PERKINS+WILL**MMC East Tower Expansion – City Design Comments**

To:	Al Green
From:	Jeffrey Keilman
Date:	March 19, 2018
Subject:	MMC East Tower Expansion – City Design Comments – Workshop 2 Response
Attachments	MMC IDP Design Review_prelim2

Re: MMC East Tower Expansion – City Design Comments – Workshop 2 Response

NORTH ELEVATION

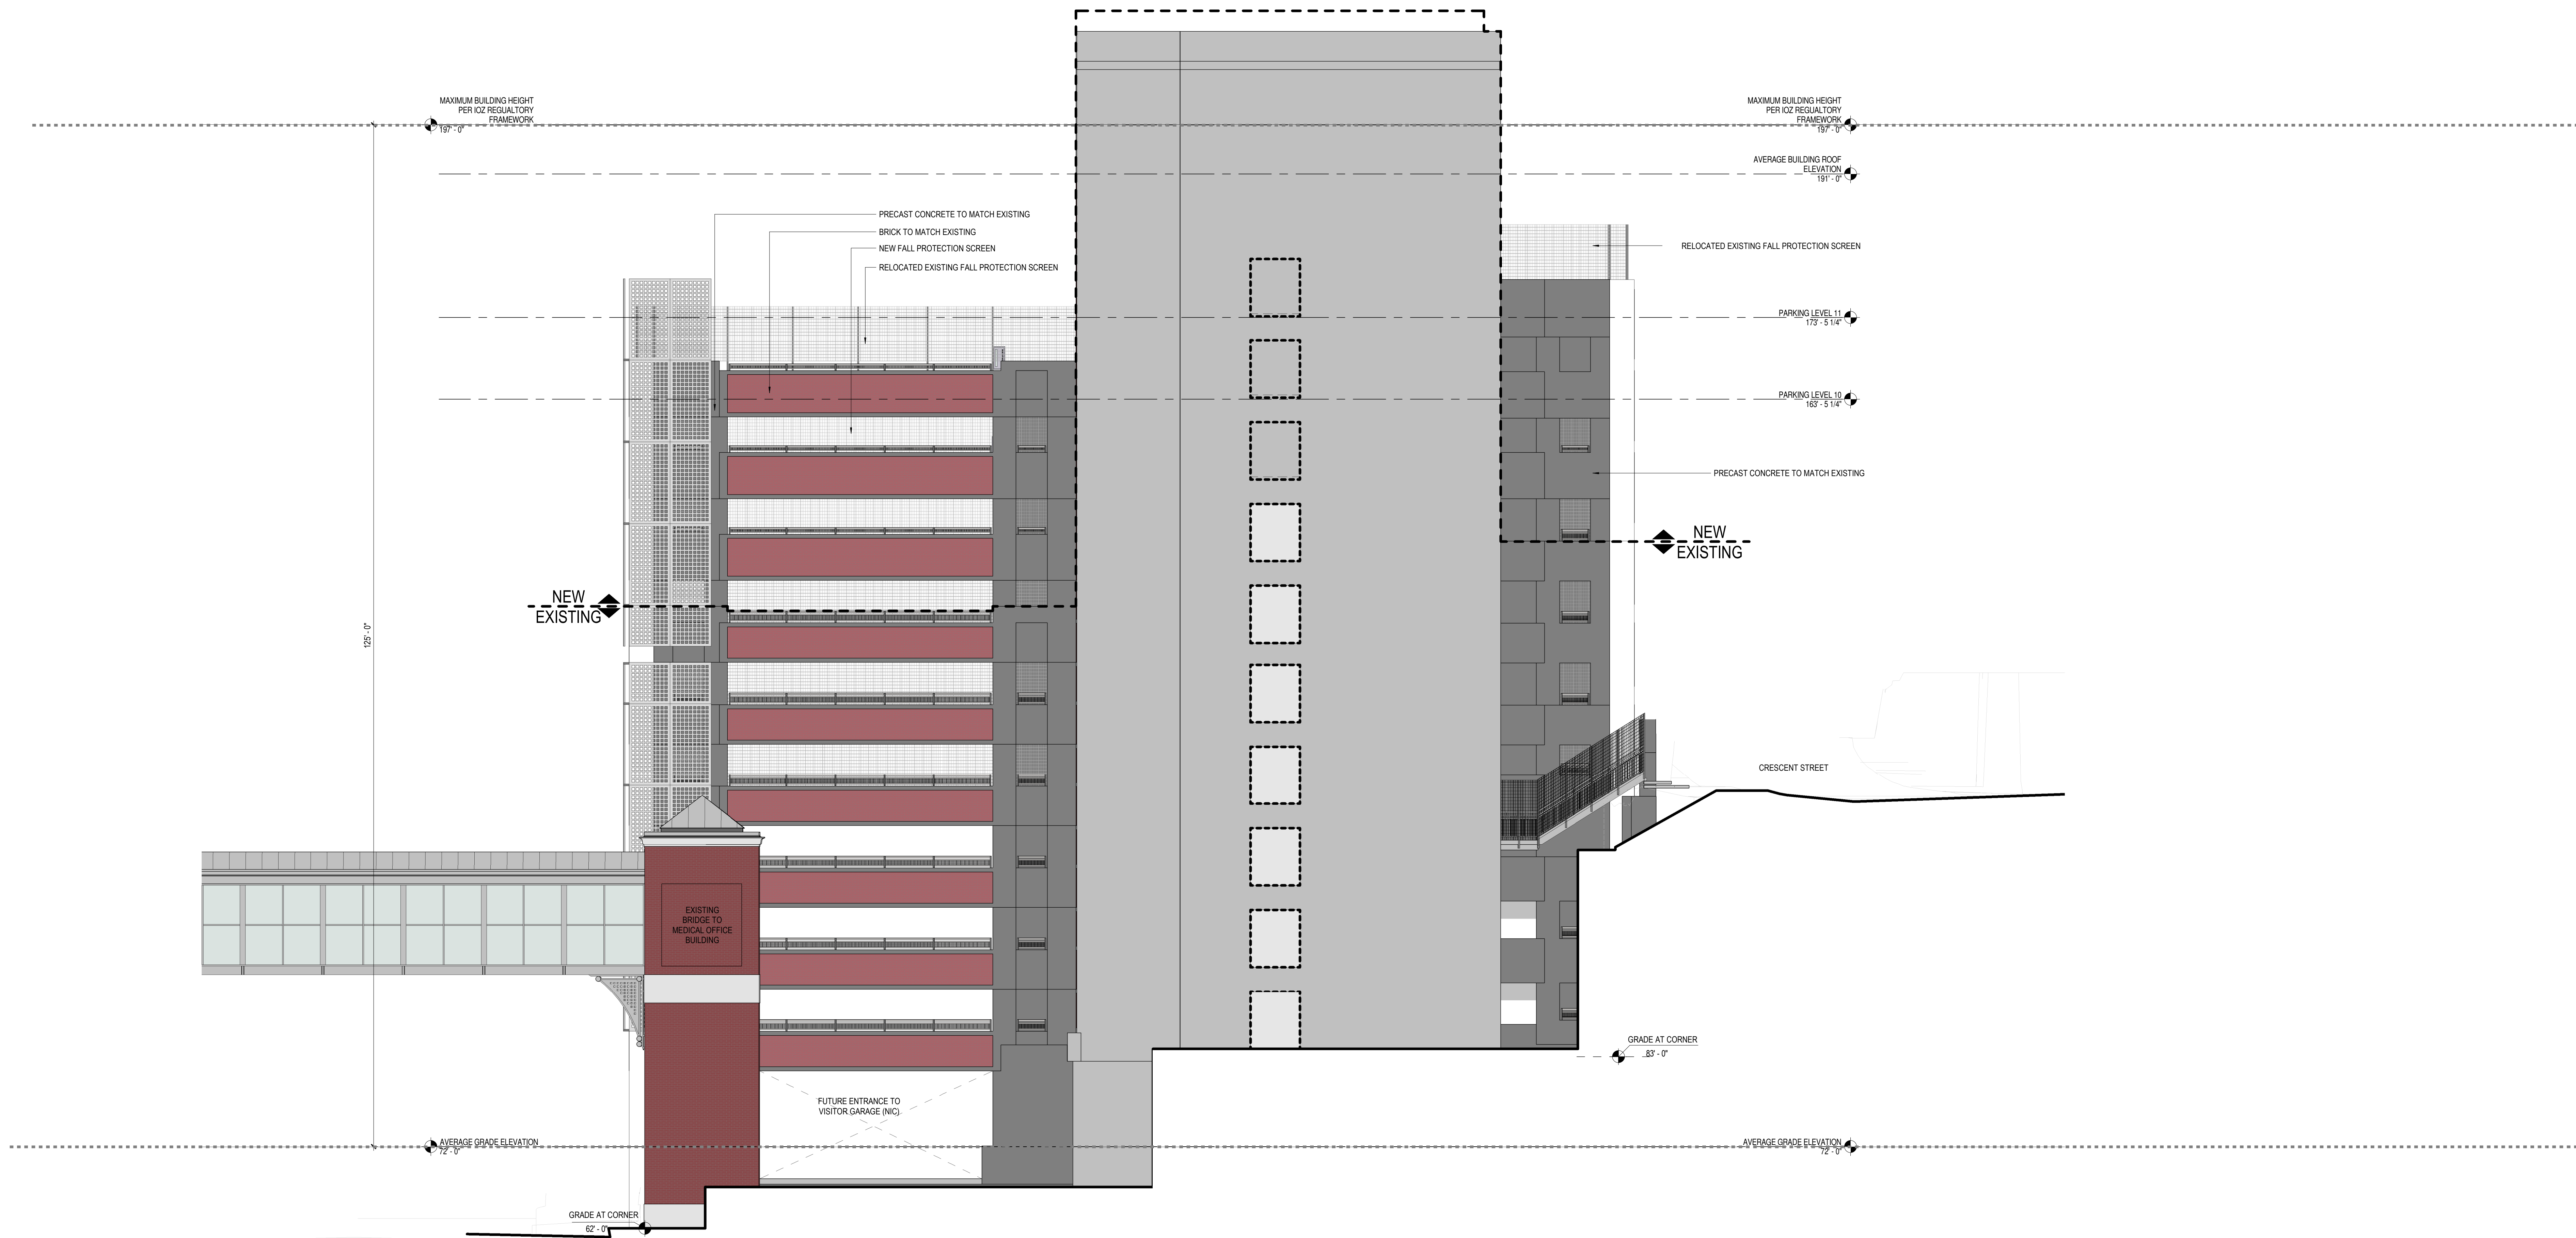
Visitor Garage: *Congress Street is a major street and this building will become even more visible from long views as it grows in height. The garage proposal lacks visual interest from long views – articulation and visual interest are important for the garage in the forefront of the campus. Planning Board asks that the applicant re-evaluate the approach. Although staff and Planning Board acknowledge it is not realistic to completely redo the siding of the garage, consider options like adding decoration to give three-dimensional life to the façade, laser cut metal panel. The roofline is an element where visual interest could be added - Planning Board commented that the simple roof form does not have enough visual interest for the long views.*

Planning Board commented on the lack of visual interest on upper floors and feel this guideline is not met – roofline, façade material, fall protection/screen design are possible architectural elements that can address this guideline. Street activation guideline is met, see comments 7. above.

Long views were developed for further review per recommendation of City Staff. The expansion of the Visitor Garage does increase its height but the ability to see the expansion is limited from long views. However, per comments as heard from the Planning Board and reiterated by City Staff, options were developed on how to modify the existing screening elements on the garage. Upon review, an option that extends the screening above the last spandrel panel was desirable by all that reviewed for it broke the horizontal plane of the roofline and created a layering between the screens, fall protection, and precast concrete panels.

Long views were developed for further review per recommendation of City Staff. The expansion of the Visitor Garage does increase its height but the ability to see the expansion is limited from long views. However, per comments as heard from the Planning Board and reiterated by City Staff, options were developed on how to modify the existing screening elements on the garage. Upon review, an option that extends the screening above the last spandrel panel was desirable by all that reviewed for it broke the horizontal plane of the roofline and created a layering between the screens, fall protection, and precast concrete panels.
